# KITTITAS COUNTY

## DEPARTMENT OF PUBLIC WORKS

SUBJECT: The Duke Short Plat SP-07-167

Our department has reviewed the short plat application and has the following comments:

SP-07-XX

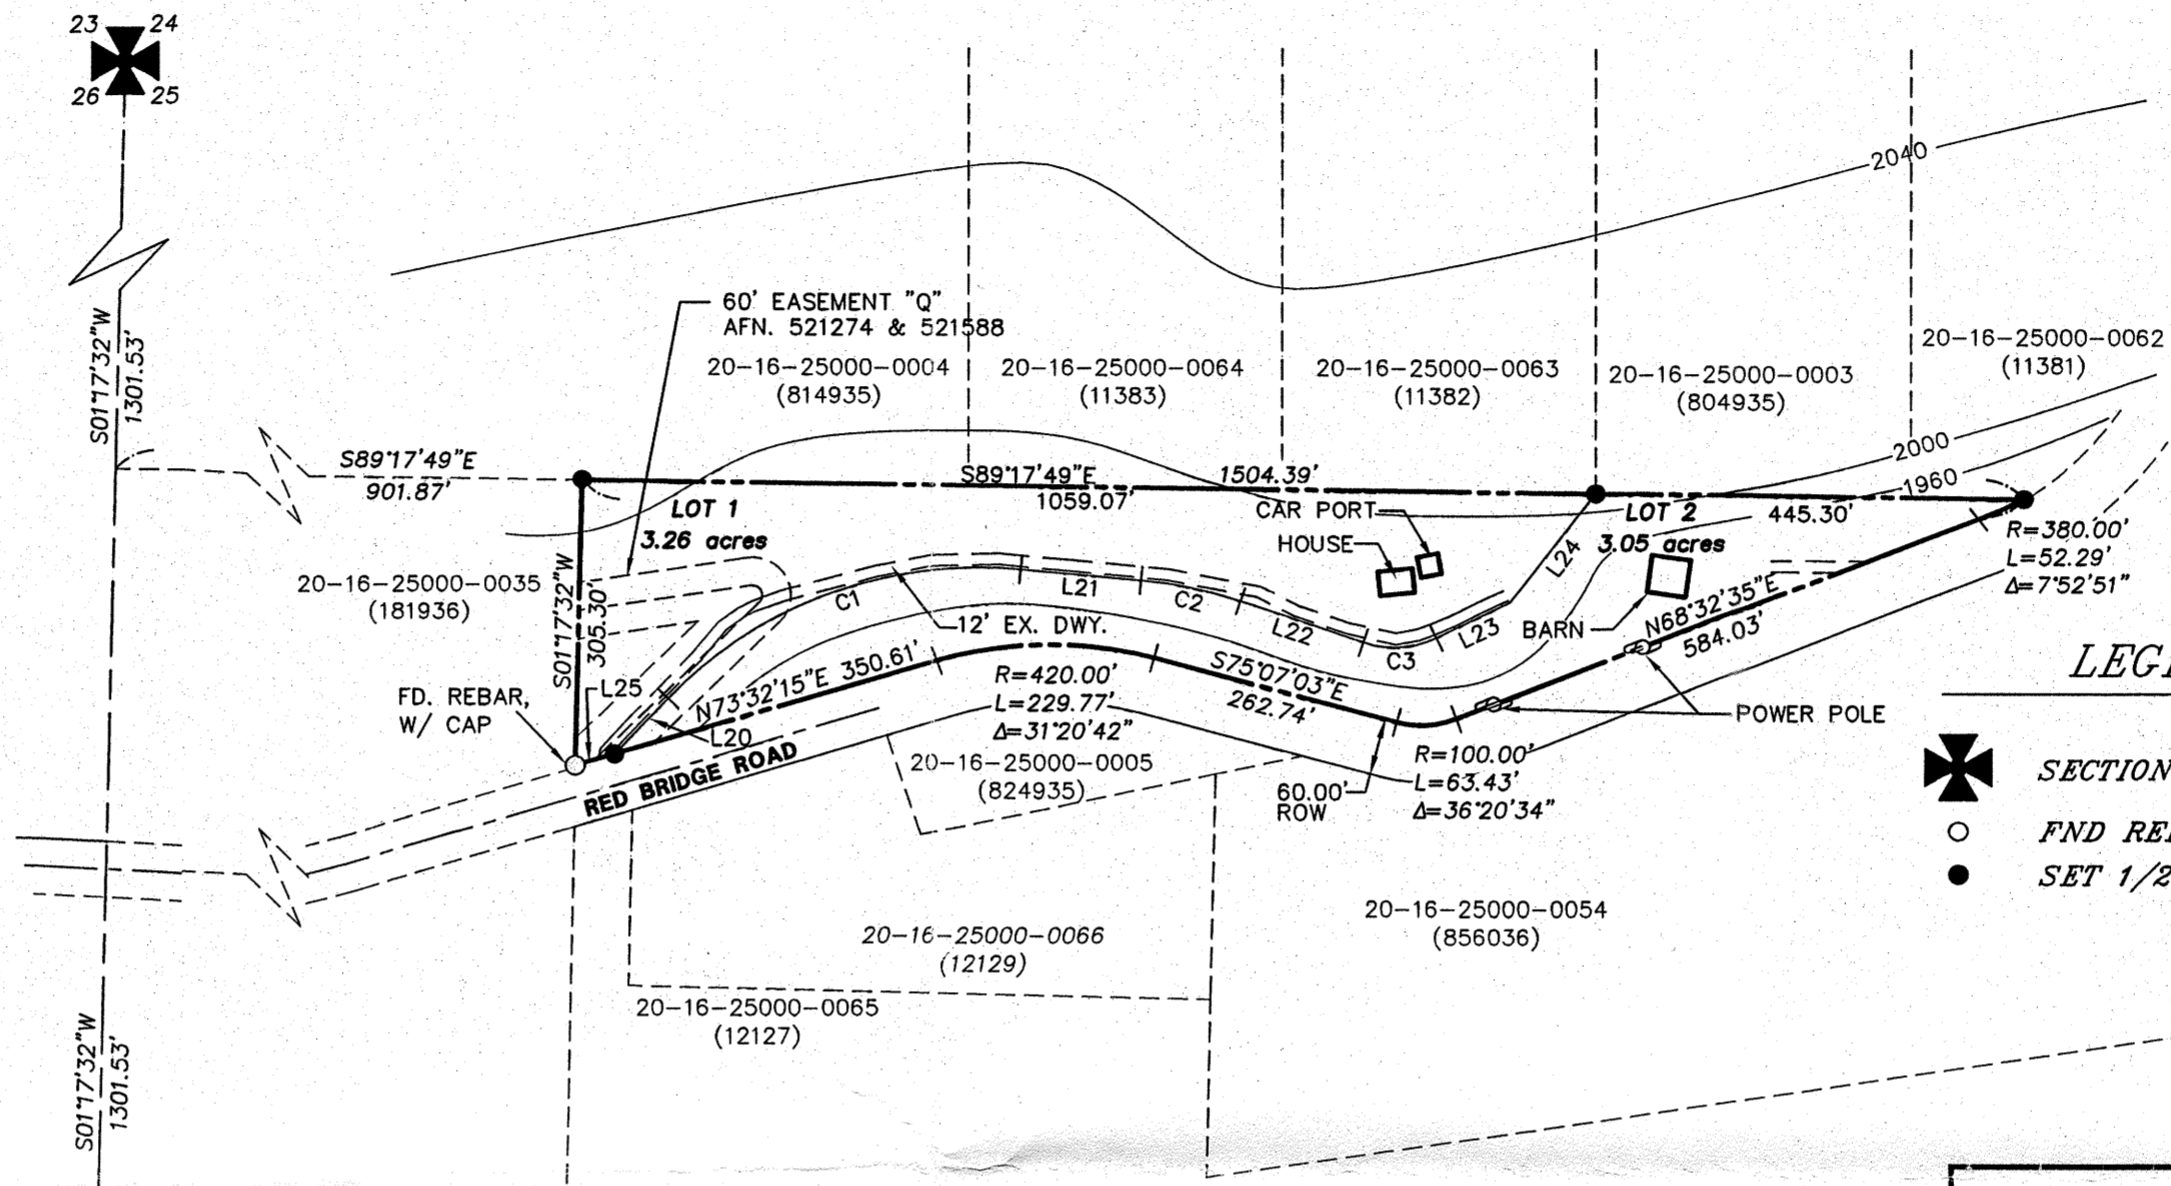
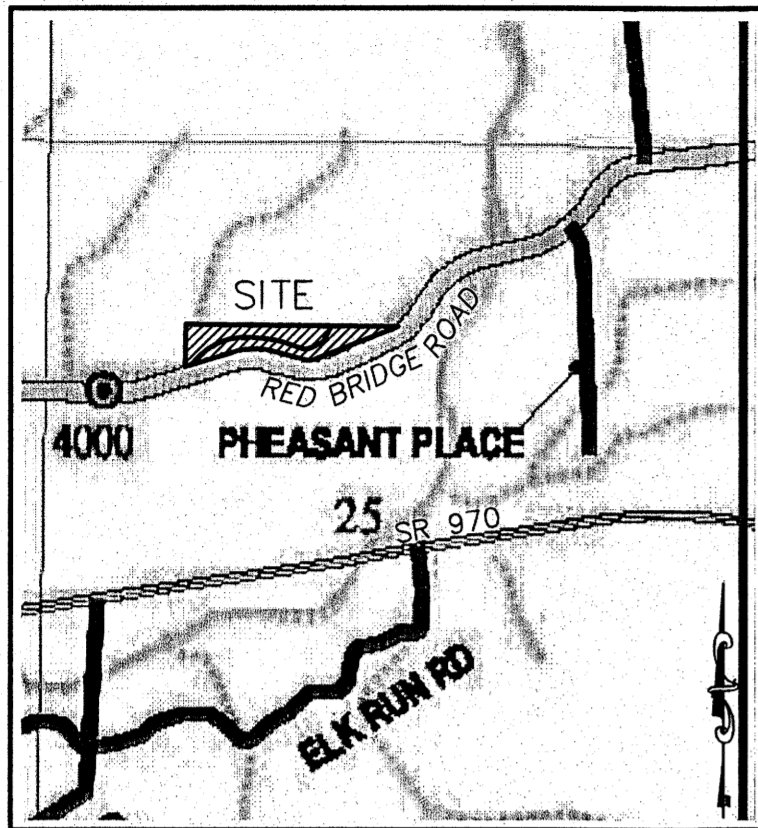
1. Tax Lot Number: The tax lot number listed in the Treasurer's approval box appears to be incorrect.
2. Lot 2 Access: Access to Lot 2 is proposed to be directly from Red Bridge Road. If access is from the 60' access easement additional improvements will be necessary, including the construction of a high density road that serves 3-14 lots, an emergency turnaround, and a road certification prior to receiving a building permit.
